15th June 2023

Heckington Fen Solar Park Statutory Consultation – Lincolnshire Wildlife Trust Comments

FIGURE 4.1e PROPOSED ECOLOGICAL ENHANCEMENTS FOR OPERATIONAL ENERGY PARK

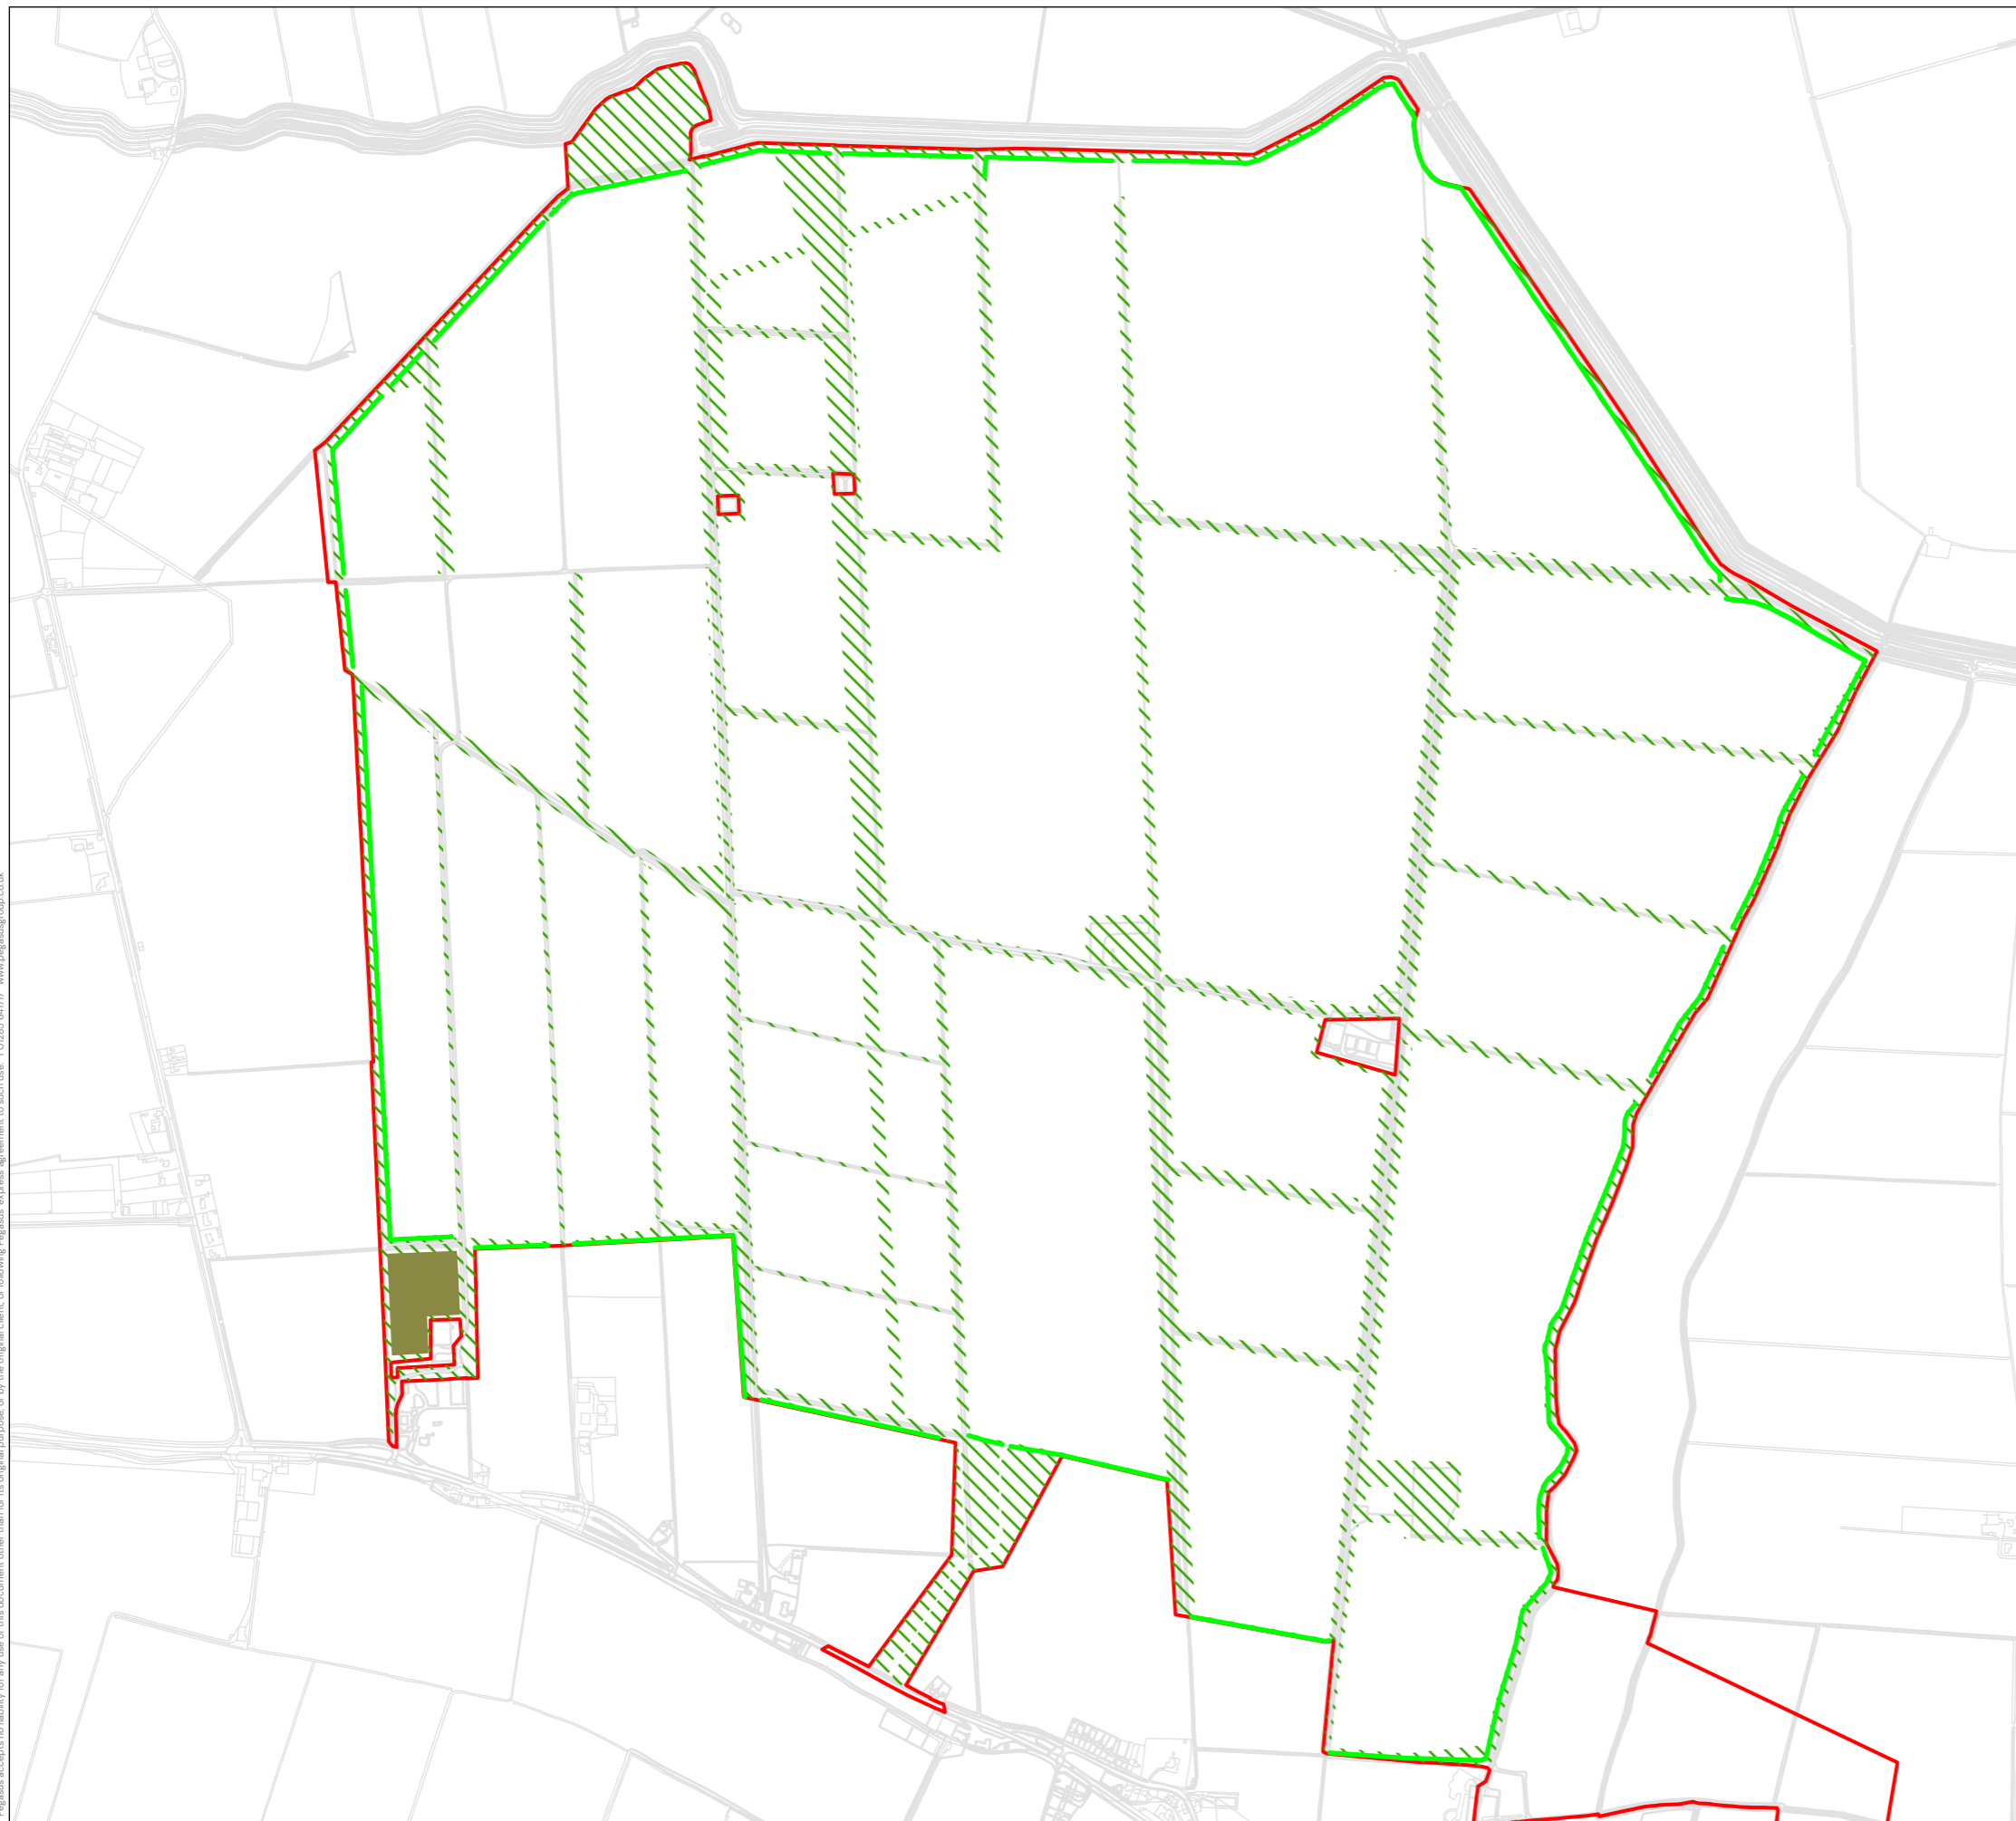
The proposed ecological enhancements for the park during its operational phase (figure 4.1e) shows the various intersecting boundary treatments forming wildlife corridors through the site to the surrounding landscape (with Head Dike being an ecologically significant connection along the northern boundary). The work conducted during consultation to move various infrastructure and equipment closer together onsite and at fewer locations (February 2023 update) improves this further.

The habitat enhancement areas have been reduced in number following consultation and agricultural land grade assessment. This reduced enhancement area would still result in a high BNG value for the site (though this has yet to be calculated for the development since) while allowing the fields between the A17 road and the panel arrays to remain in agricultural production. This loss in area has meant the latest revisions do not include dedicated areas for skylark plots which require large areas of open space for breeding success. The field parcels to contain panel arrays, and their enhanced sward as a result, are likely to be suitable feeding areas of skylarks but these should also be supplemented with viable breeding spaces. There are currently few, if any, records of skylark successfully breeding between panel arrays of solar farms, though there is scant research in this area.
